Appeal Decision

Appeal Ref: APP/R4408/D/18/3194385

2 Church Street, Great Houghton, Barnsley S72 0BL

- The appeal is made under section 78 of the Town and Country Planning Act 1990 against a refusal to grant planning permission.
 - The appeal is made by Mr David Randerson against the decision of Barnsley Metropolitan Borough Council.
 - The application Ref 2017/1389 was refused by notice dated 11 December 2017.
 - The development proposed is the erection of a detached garage.
-

PLAN AND ELEVATIONS

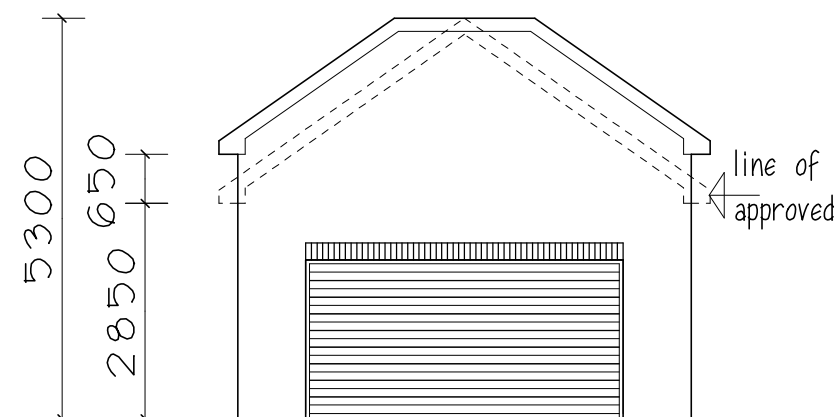
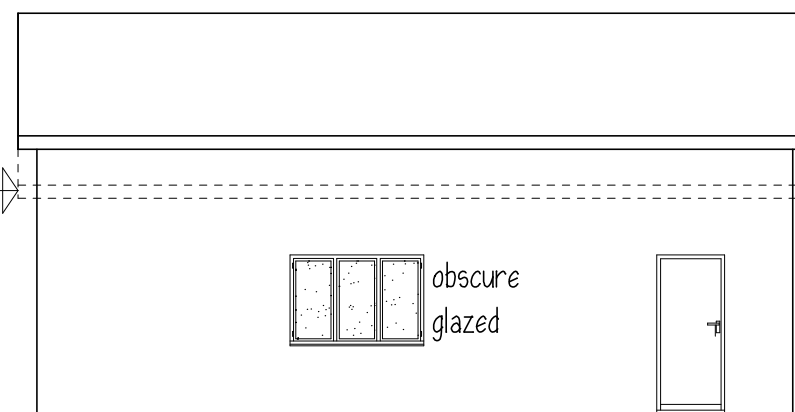
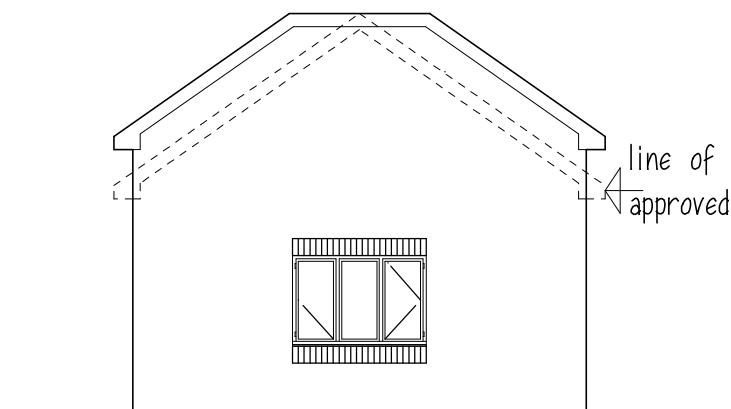
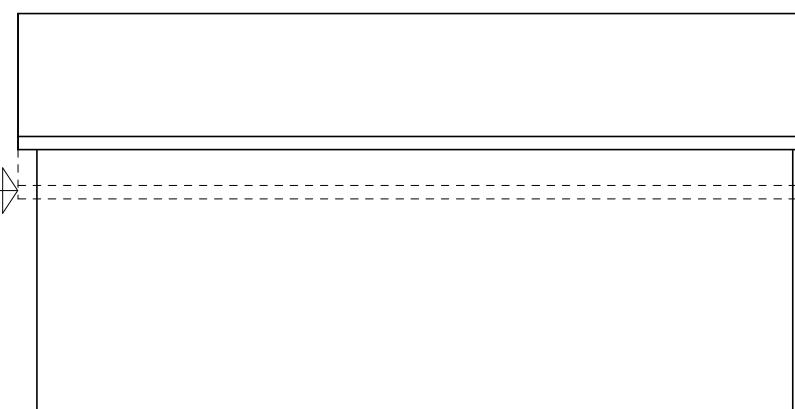
4. The development for which planning permission is sought is a detached garage to the rear of the appeal property, which is a 2-storey end terrace dwelling in a predominantly residential area. The new garage would be a sizeable addition. It would have a ridge height of 5.3-metres, a length of 10-metres and a width of 6-metres. Although no taller, it would be more substantial in built form than the detached garage that was recently granted planning permission¹ in broadly the same position and with the same footprint as the appeal scheme.

5. The proposed building would be simple in design and a condition could be imposed to ensure that the external materials would be appropriate. However, the new garage would be significant in scale and mass. The relatively high eaves level and a part flat roof would combine to visually accentuate its considerable bulk. Taken together, the proposed development would appear overly large and atypical of garages and other ancillary outbuildings that are generally found to the rear of residential properties.

through the gap at the side of No 2. From this vantage point, the completed building would draw the eye as an uncharacteristically large and bulky addition. At the site visit, I saw no buildings or structures to the rear of residential properties in the area around the site that would be comparable in scale or mass to the proposal. For these reasons, the proposed development would be obtrusive in the street scene and an unwelcome addition to the local area. The amendments made to the design and internal layout of the proposal do not, therefore, overcome some of the objections raised by the Council to an earlier proposal that included first floor windows and a dual pitched roof².

7. The Council's Supplementary Planning Document, *House Extensions*, states that detached garages should relate sympathetically to the main dwelling in style and proportions with a maximum eaves height of 2.5-metres from ground level. The National Planning Policy Framework also notes that planning should always seek to secure high quality design and that new development should add to the overall qualities of an area. For the reasons given, the proposal would not be in accordance with these important principles.
